Re: Objection to MP08_0244 MOD 1 Modification Request for Mixed Used Development at 23-37 Lindfield Avenue and 11 Havilah Lane, Lindfield

DRAWING TITLE:
SHADOW DIAGRAMS - JUNE

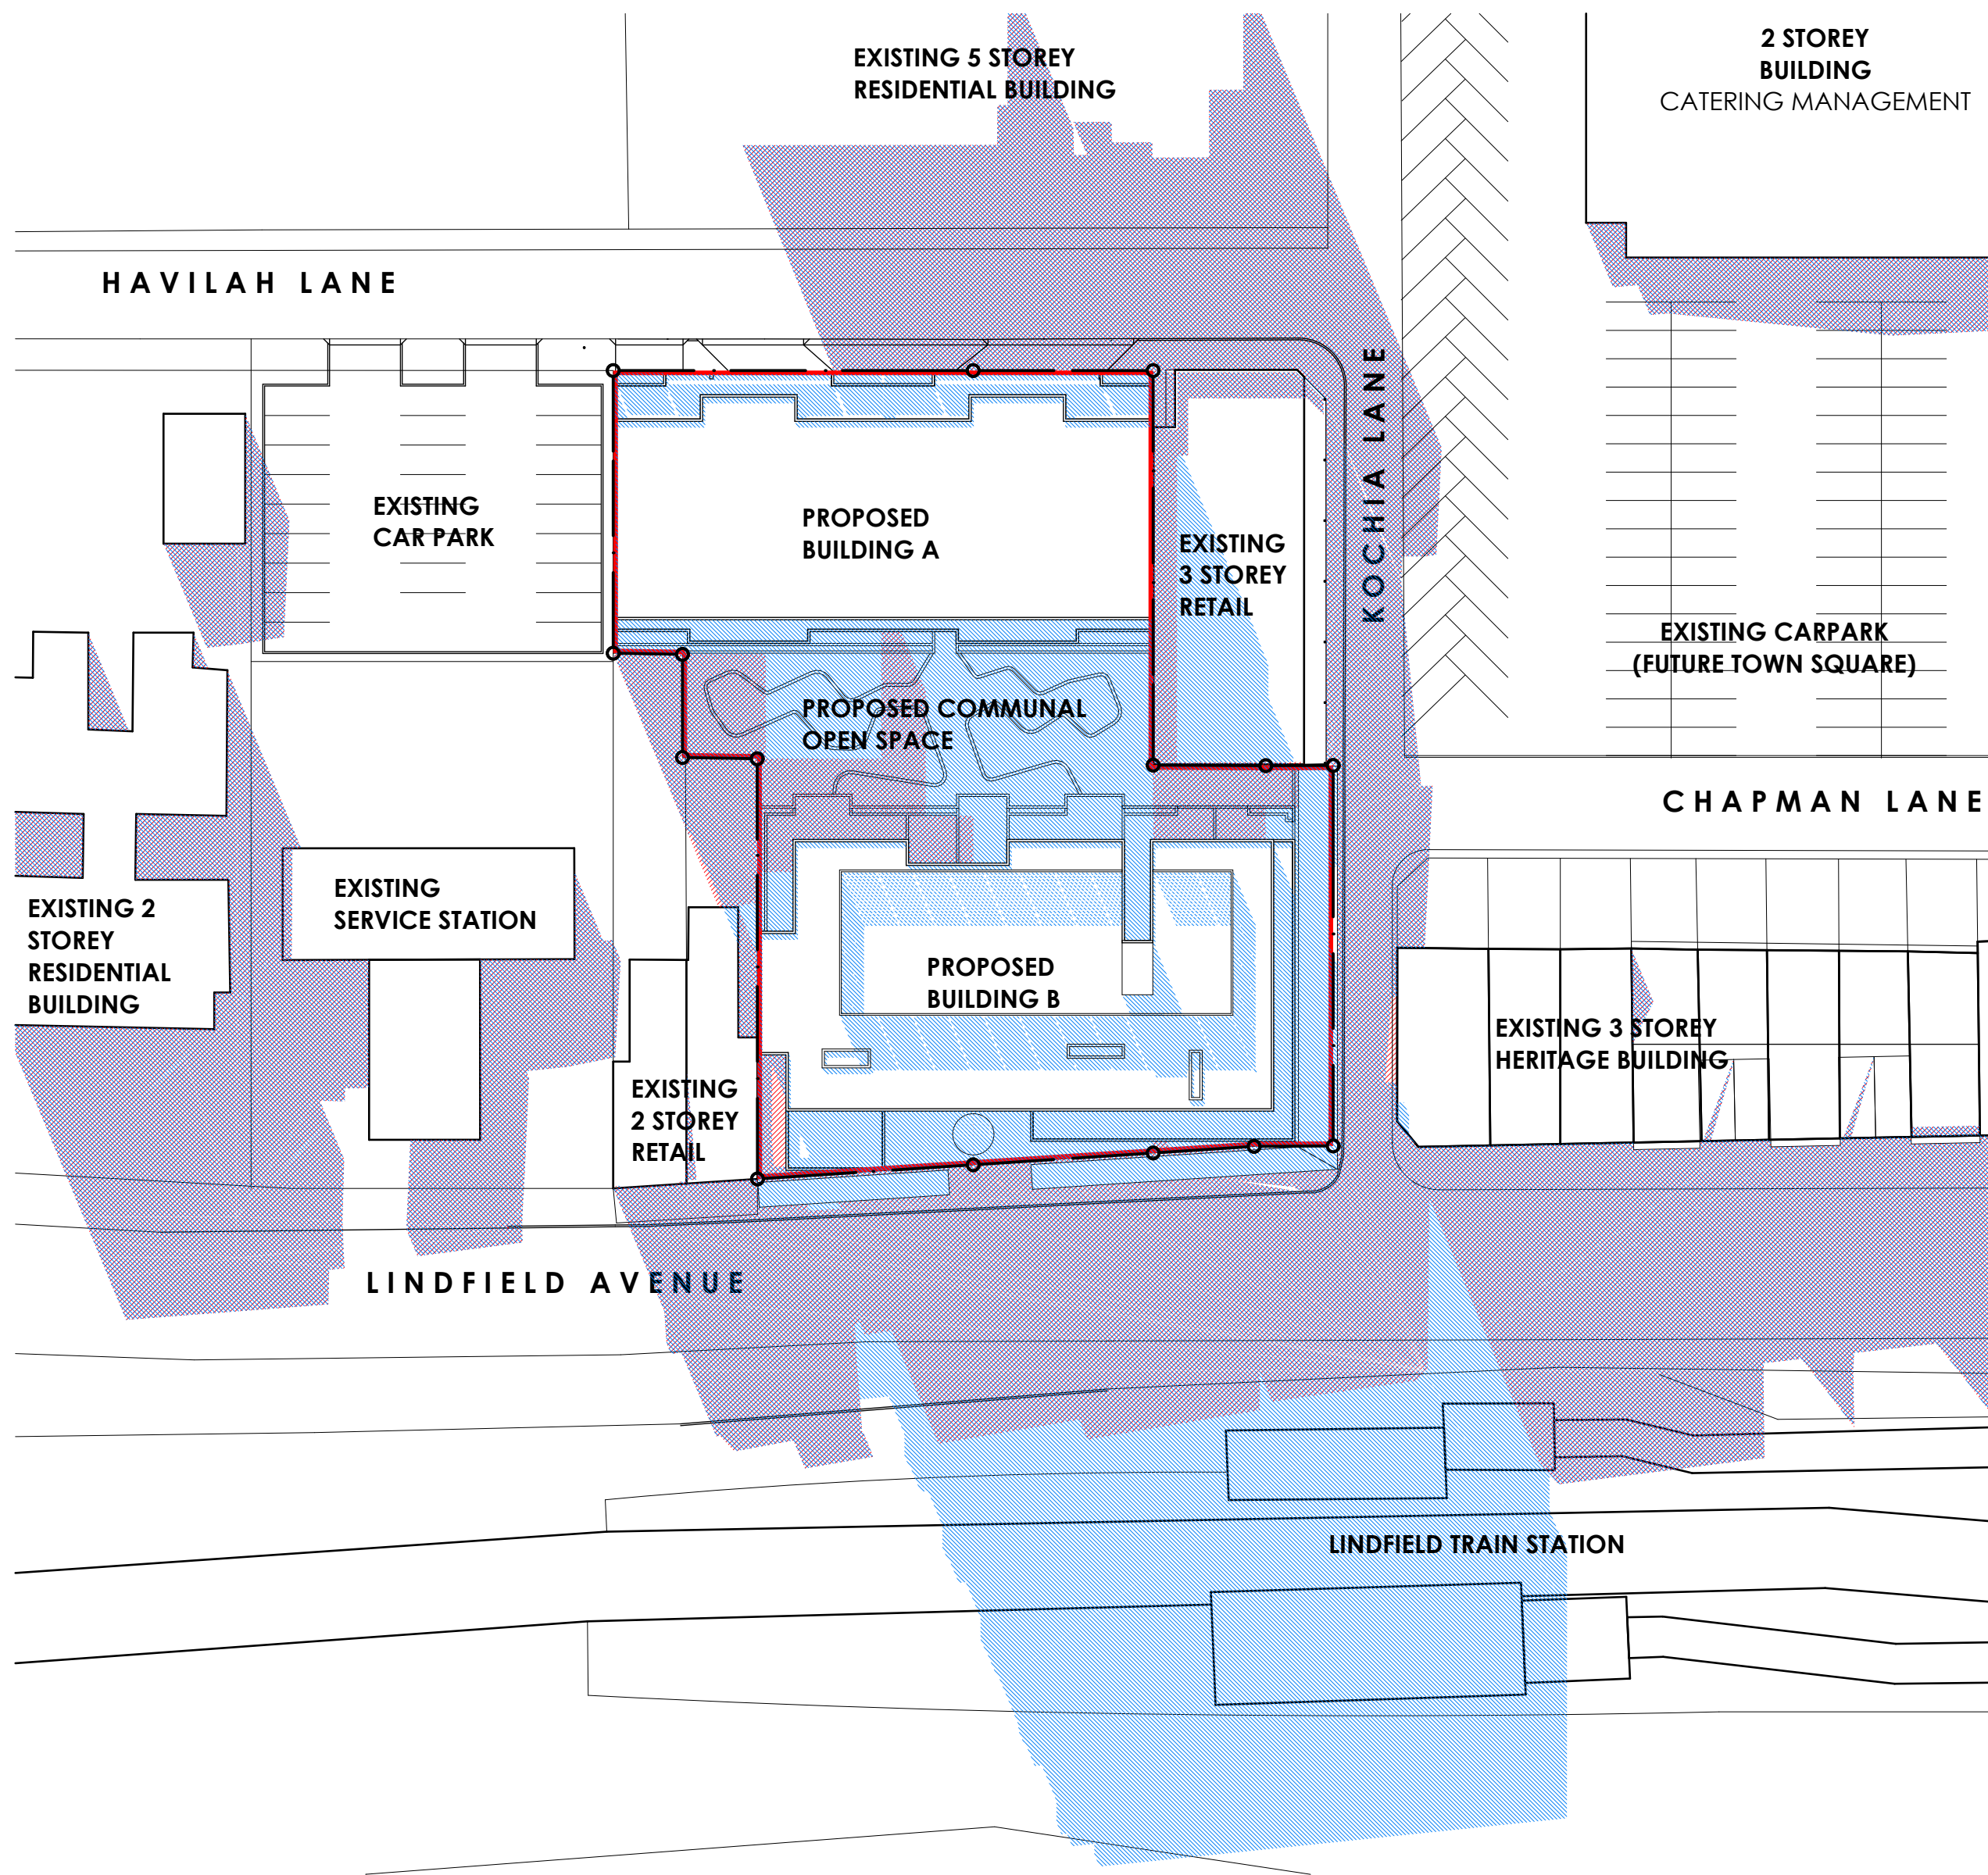
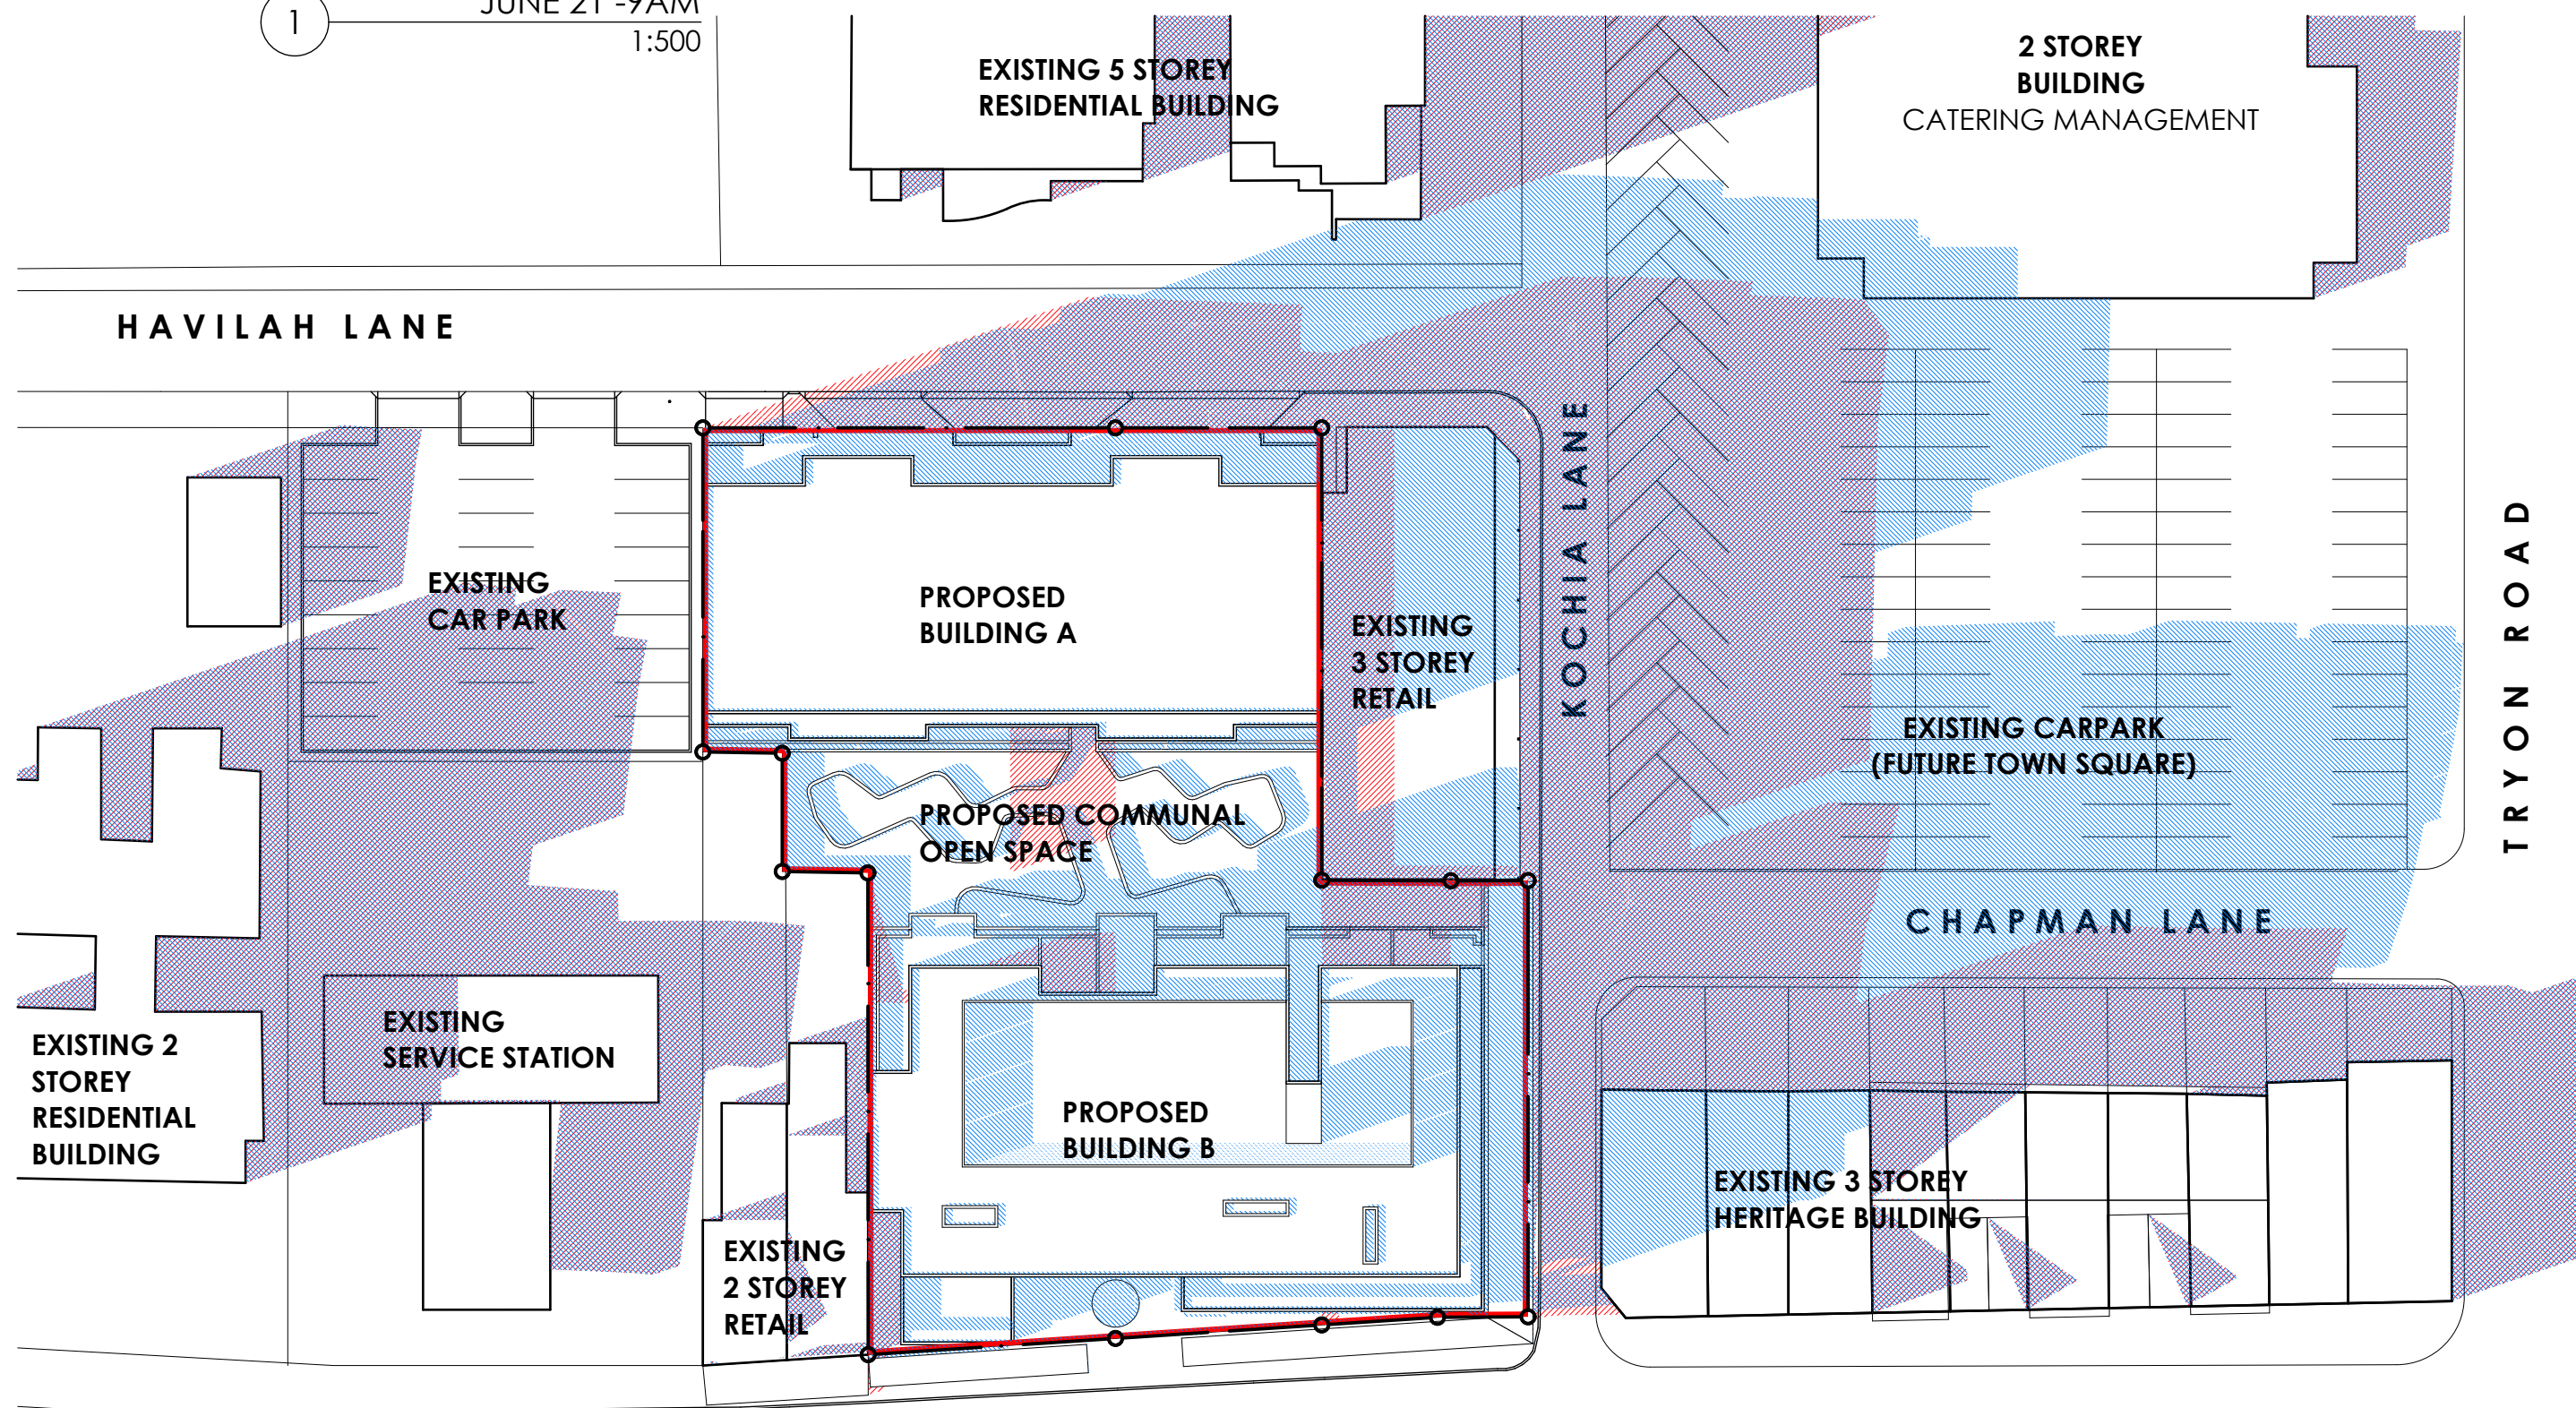
- The additional storeys create new adverse shadowing: a) for residents in the Havilah Lane apartments, particularly after 3pm b) for the popular outdoor café and central Lindfield hub area at 12 Tryon Road in afternoons, particularly in winter and c) for all commuters on the city bound Lindfield rail platform, instead of 50% of the year as approved, it will now be in shadow in the mornings 75% of the year
